**WELWYN HATFIELD BOROUGH COUNCIL
EXECUTIVE DIRECTOR - PLANNING, PUBLIC PROTECTION AND GOVERNANCE**

Application No: 6/2022/0951/HOUSE
Location: 13 Holme Road Hatfield Hertfordshire AL10 9LH
Proposal: Erection of single storey front extension and part first floor rear extension
Officer: Ms Kirsty Shirley

Recommendation: Refused

Date:	18 August 2021
Scale:	A3@1:1250
Dwg:	128/21 3
Drawn by:	md

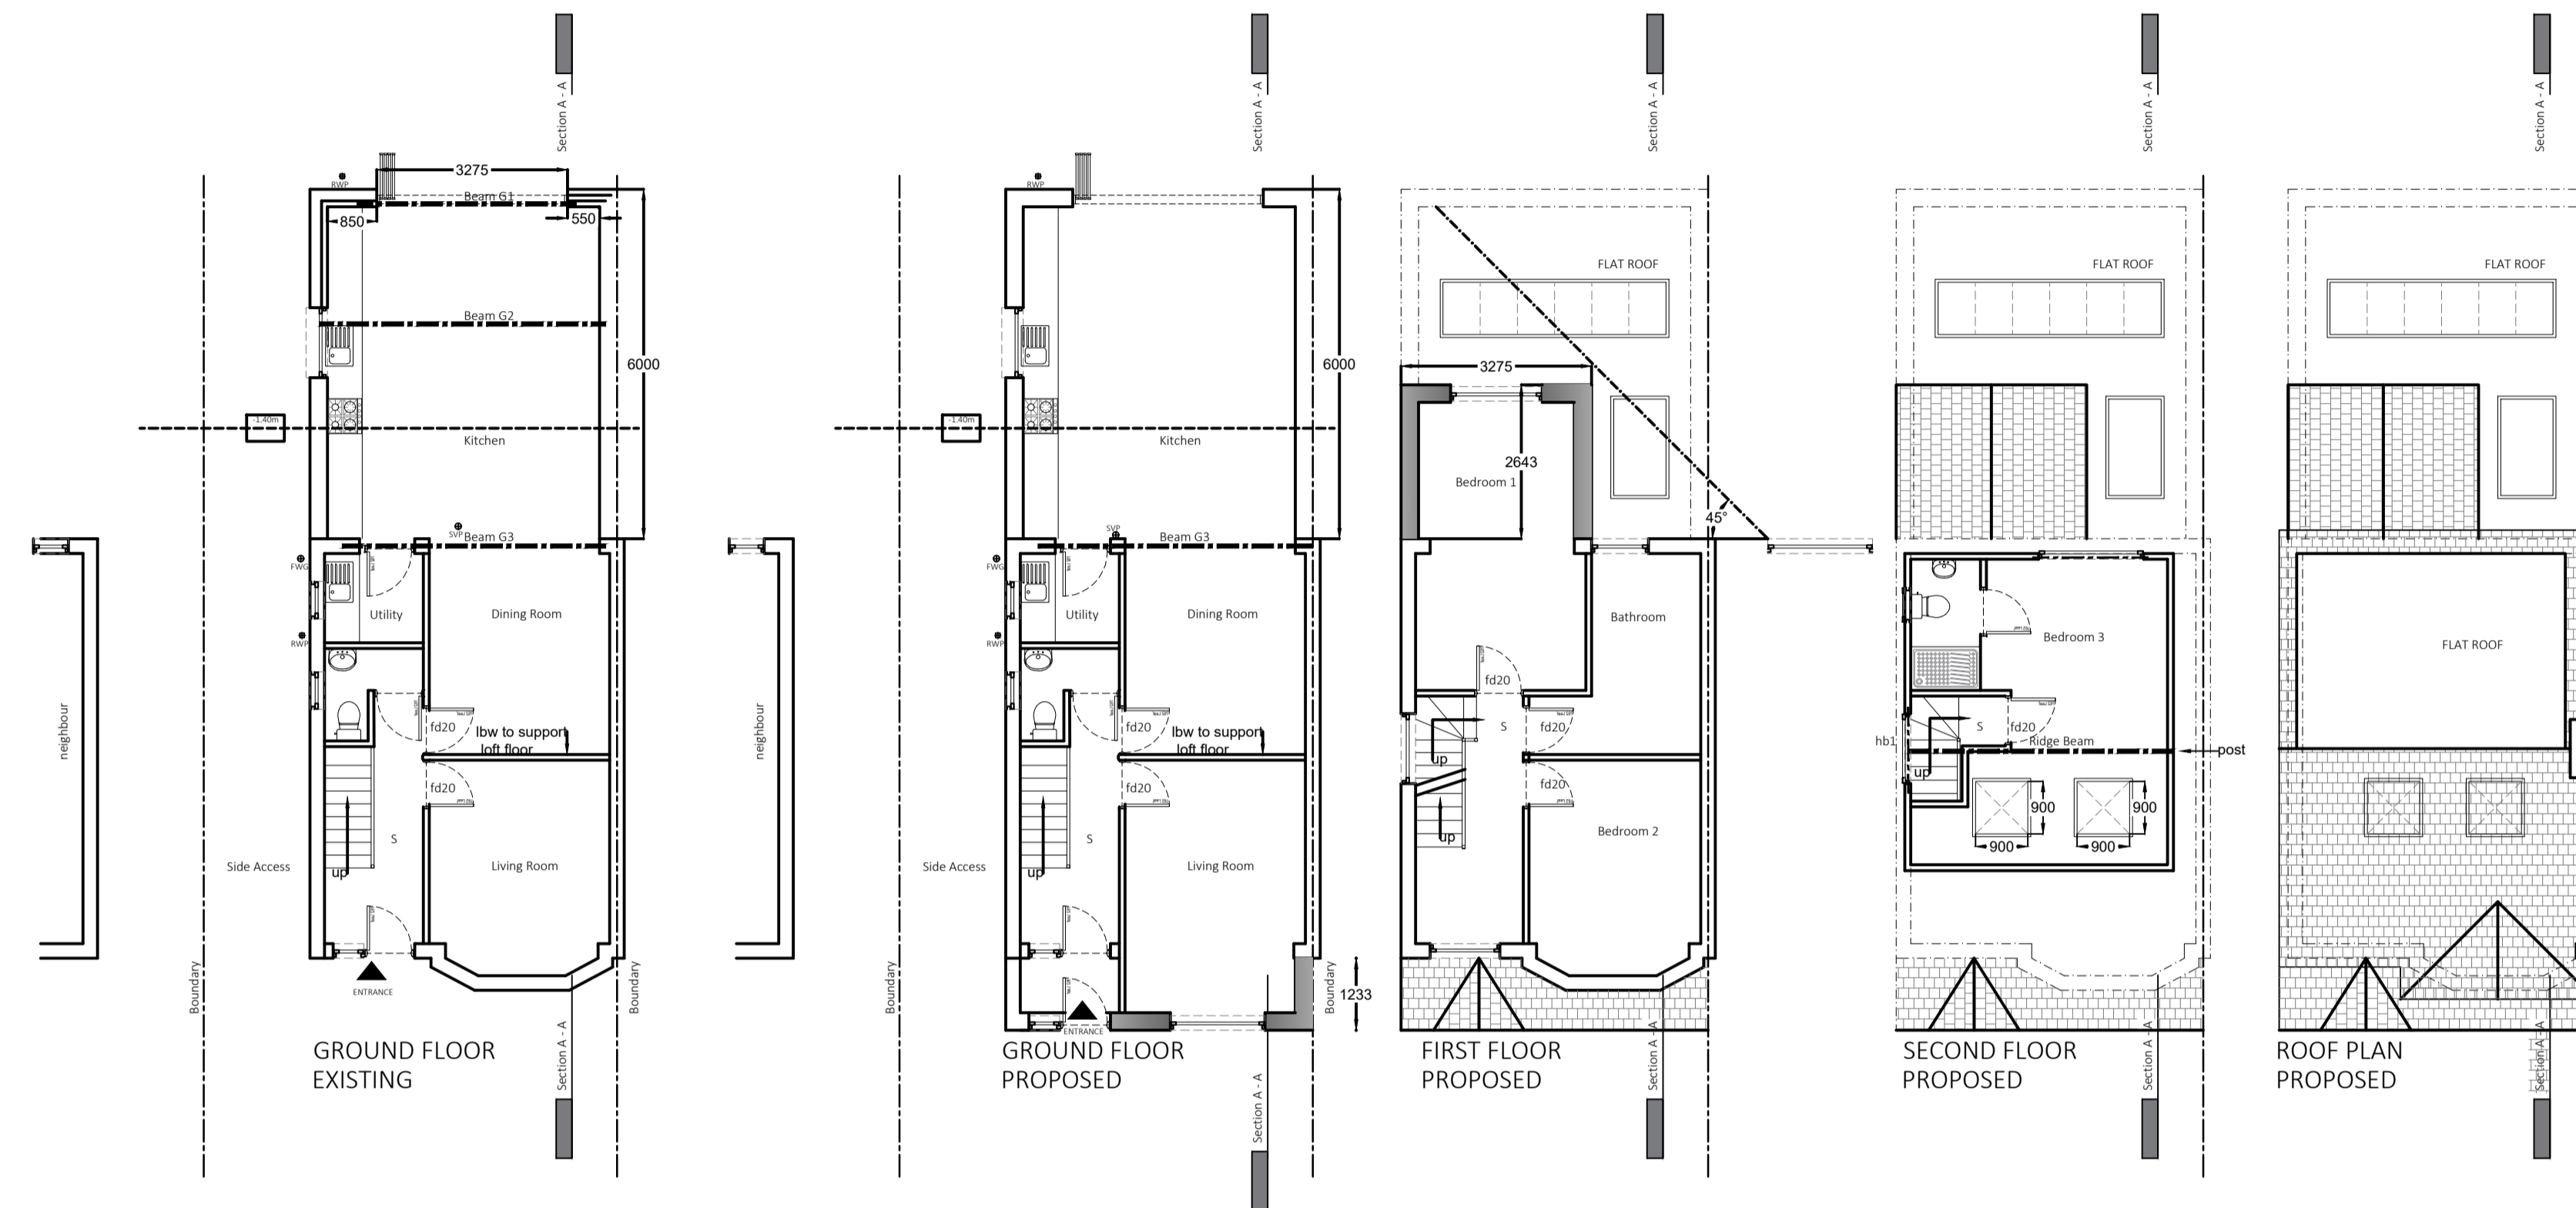
Context			
Site and Application description	The application site is located to the west side of Holme Road and is comprised of a two storey semi-detached dwelling with front driveway and elongated rear garden.		
Constraints (as defined within WHDP 2005)	PAR - PARISH (HATFIELD) - Distance: 0 Wards - Hatfield Villages - Distance: 0 A4HD - Article 4 HMO Direction - Distance: 0 HAT - Hatfield Aerodrome - Distance: 0 HHAA - Hatfield Heritage Assessment Area(Hatfield Garden Village) - Distance: 0		
Relevant planning history	Application Number: 6/2021/2196/PN8 Decision: Granted Decision Date: 31 August 2021 Proposal: Prior approval for the erection of a single storey rear extension measuring 6m in depth, 3.5m in height, 3m to the eaves		
Consultations			
Neighbour representations	Support: 0	Object: 0	Other: 0
Publicity	Neighbour notification letter		
Summary of neighbour responses	None received		
Consultees and responses	Hatfield Town Council – Comment: <i>No objections however the proposed rear elevation appears poor in design</i>

<p>Design (form, size, scale, siting) and Character (appearance within the streetscene)</p>	<p>The NPPF places great emphasis upon achieving good quality design. Paragraph 126 advises that the creation of high quality buildings and places is fundamental to what the planning and development process should achieve and that good design is a key aspect of sustainable development. Paragraph 130 of the NPPF further advises that decisions should ensure developments will function well, be visually attractive, sympathetic to local character and establish a strong sense of place. Paragraph 134 is clear that <i>‘development that is not well designed should be refused, especially where it fails to reflect local design policies and government guidance on design, taking into account any local design guidance and supplementary planning documents such as design guides and code’</i></p> <p>District Plan Policy GBSP2 notes that development within the specified settlements will be limited to that which is compatible with the maintenance and enhancement of their character. Policy D1 requires the standard of design in all new development to be of a high quality and Policy D2 requires all new development to respect and relate to the character and context of the area in which it is proposed. It notes that development proposals should as a minimum maintain, and where possible, should enhance or improve the character of the existing area. These policies are expanded upon in the Council’s Supplementary Design Guidance (SDG) which requires the impact of a development to be assessed giving regard to the bulk, scale and design of the proposal and how it harmonises with the existing building and area.</p> <p>The proposed ground floor front extension would project approximately 1.2m from the front elevation and would extend across the width of the front elevation of the dwelling. The front extension would feature a monopitch roof with a projecting gable roof above the entranceway to the dwelling. Whilst the front extension would result in the loss of the arched canopy characteristic of the application dwelling and featured within the street scene, such front extensions are also featured within the street scene, and it is considered that the design and scale of the proposed front extension would not detrimentally detract from the character of the dwelling or the appearance of the wider area.</p> <p>The proposal also includes a part first floor rear extension. The extension would project approximately 2.6m from the rear elevation of the dwelling and would extend over half the width of the dwelling house. The rear extension would feature a gable roof that projects from the eaves of the existing dormer window. The rear extension and gable roof would occupy a substantial amount of the rear elevation which would be concentrated to one side of the dwelling, appearing overbearing towards the application dwelling and resulting in an unbalanced and discordant design. The proposed rear gable roof would also jar with the roof forms featured on the dwelling, including the flat roof of the dormer and the gable roof of the dwelling.</p> <p>Consequently, it is considered that the proposed first floor rear extension would represent a poor standard of design, contrary to District Plan Policies D1 and D2; the Supplementary Design Guidance; and the National Planning Policy Framework.</p>

1. The proposed first floor rear extension would represent a poor standard of design, contrary to District Plan Policies D1 and D2; the Supplementary Design Guidance; and the National Planning Policy Framework.
